Flood Risk Assessment - EA Objection – Ref NO/2023/115662/01-L01 - RESPONSE

We have reviewed the EA's letter of objection in relation to planning application 3/2023/0754. The EA give 4 reasons, each of which we have duplicated below, together with our response for consideration.

dwg purpose  
Proposed Car Park

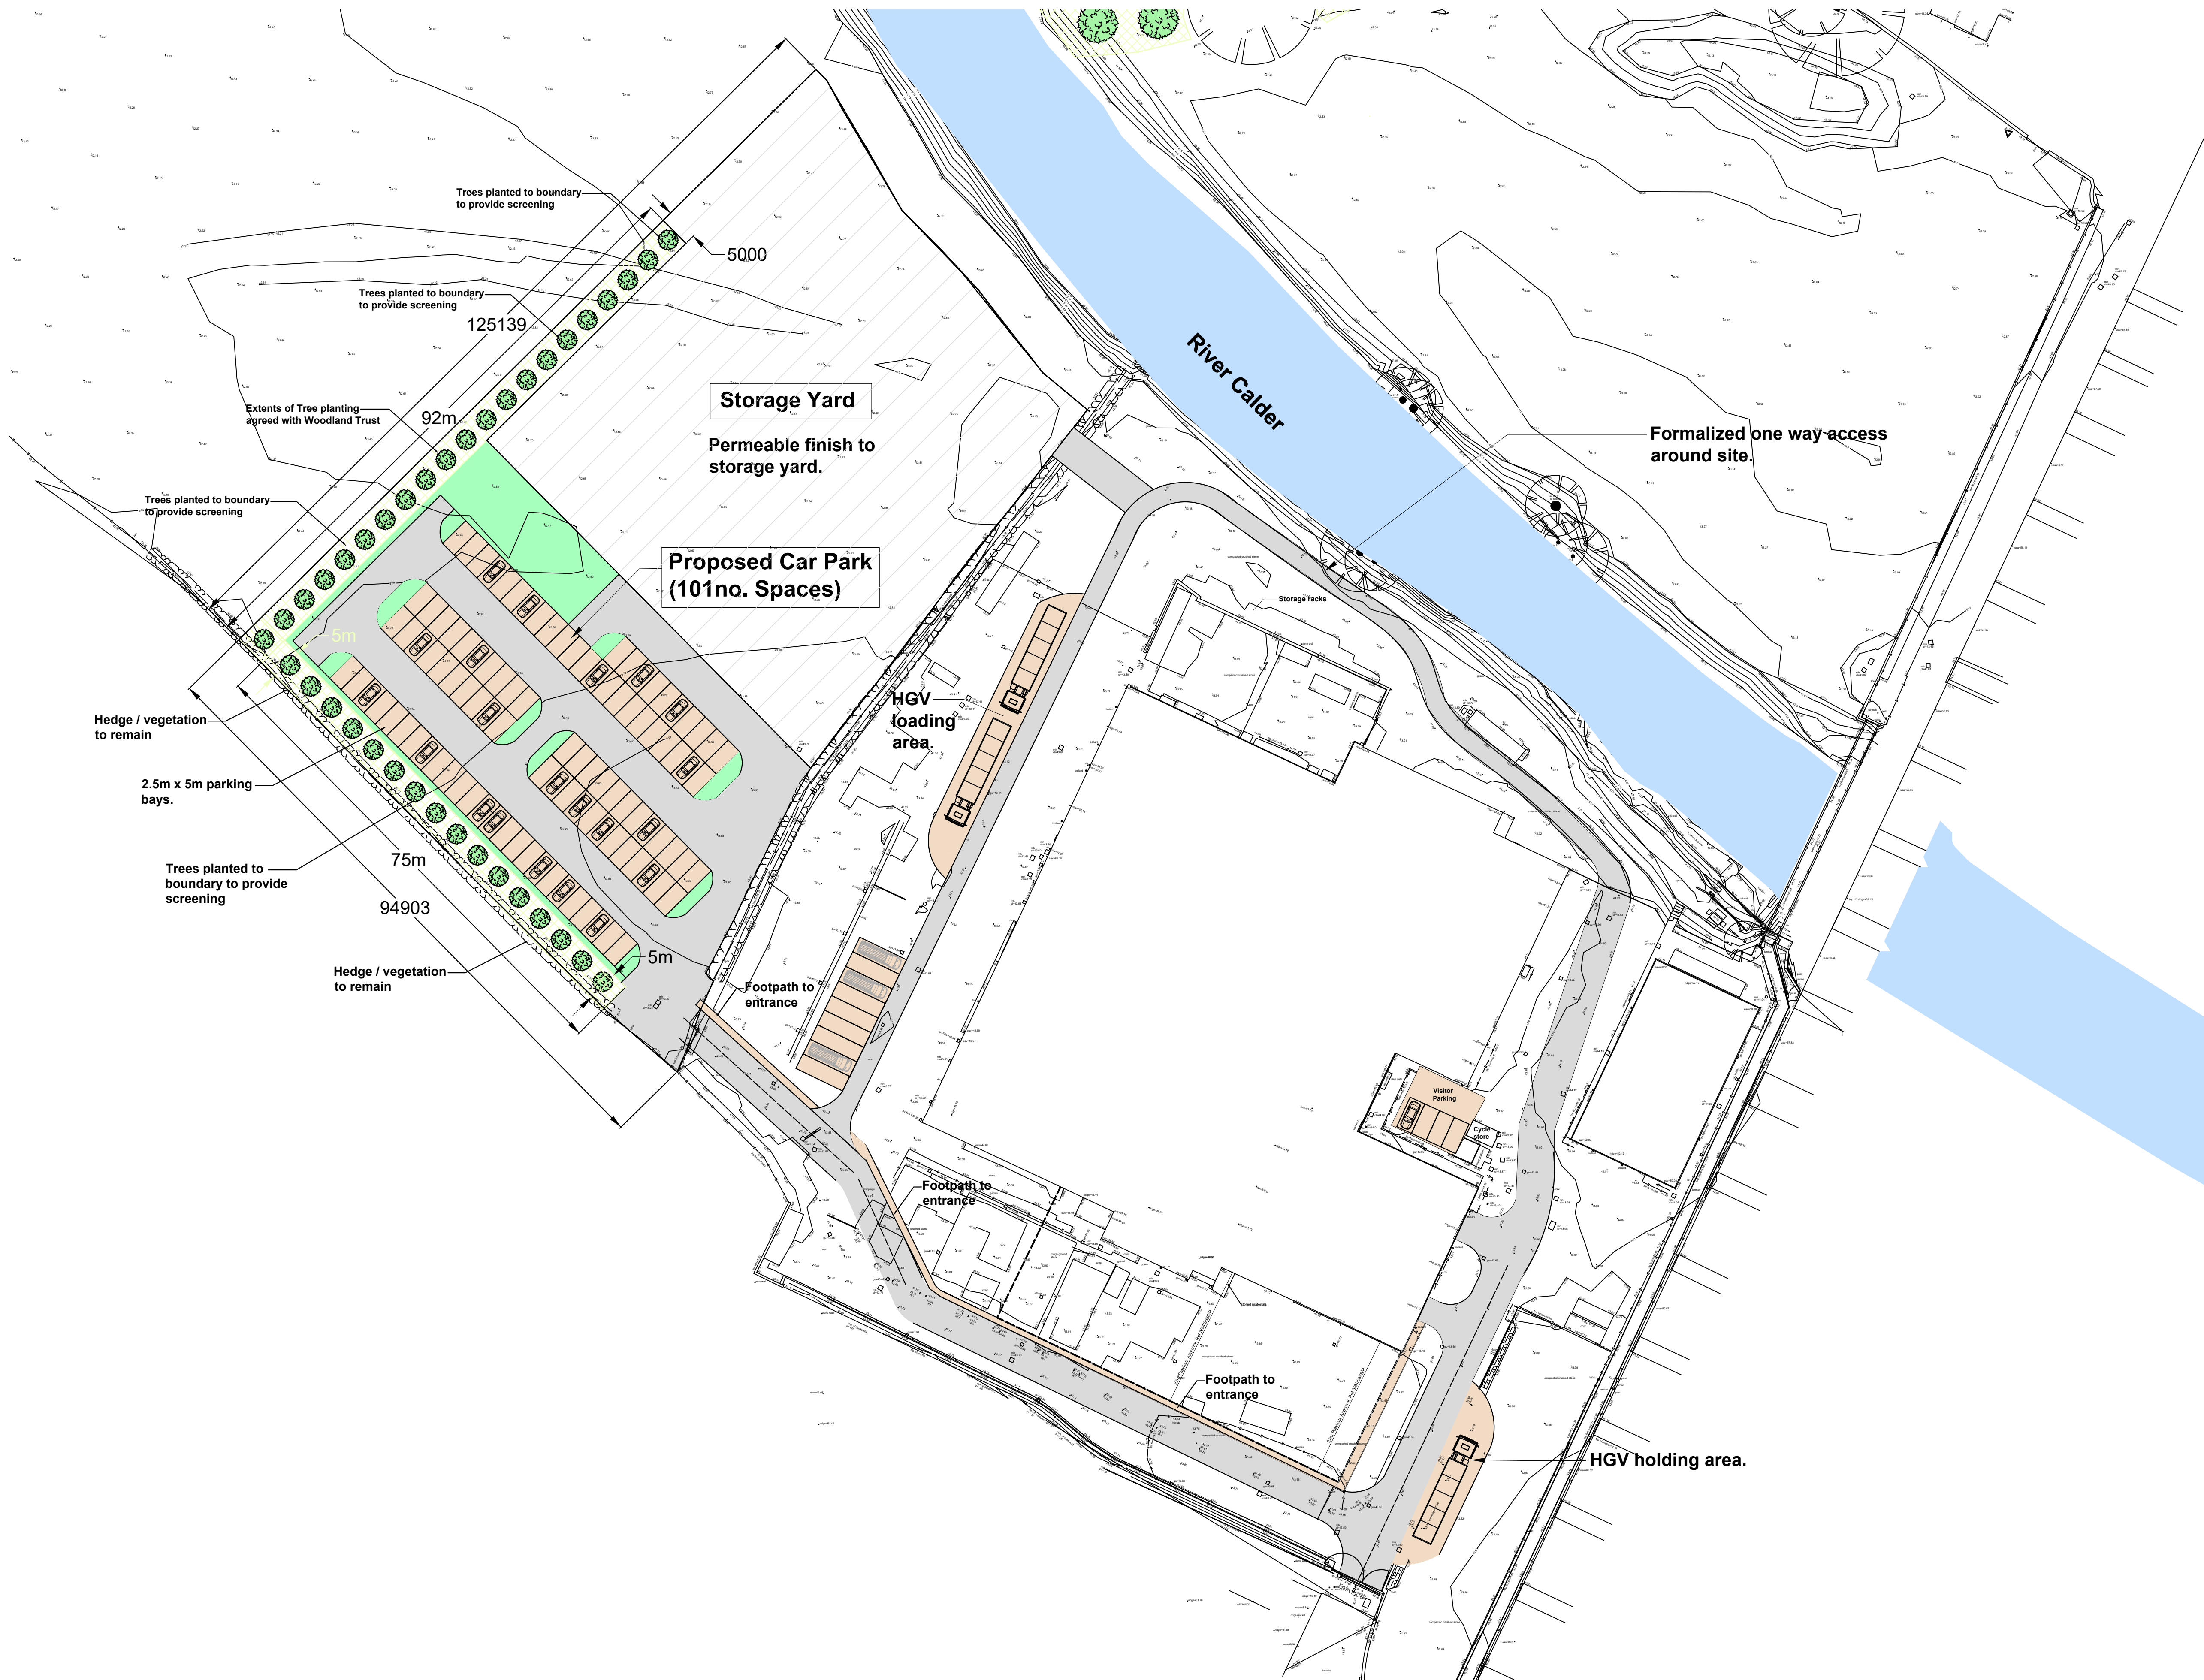
1. Identify pre and post-development ground levels

2. Evidence that there will be no displacement of flood plain storage

3. Demonstrate that the proposal will not increase flood risk off site

Review of the topographical survey shows the site is generally flat with shallow fall, generally from east to west. As the intention is to deliver a permeable storage yard and car park, there is no intention to alter existing ground levels and we can therefore confirm that ground levels will be the same, or lower than existing.

Given levels will be no higher than existing, topographically, by default, there can be no displacement of flood plain storage. In fact, given the ground will be resurfaced in a porous solution, storage volumes will be increased accordingly due to the open nature of the sub-strata. The business owner has also stated "It would not be our intention to create significant obstruction to flood flow and sympathetic storage layout will be implemented. If anything, the addition of the larger area will improve our current layout, which due to volume, could be considered more obstructive".

For reasons stated in points 1 and 2 above, it is expected that the inclusion of large areas of porous pavement will likely have a positive benefit on flood risk elsewhere
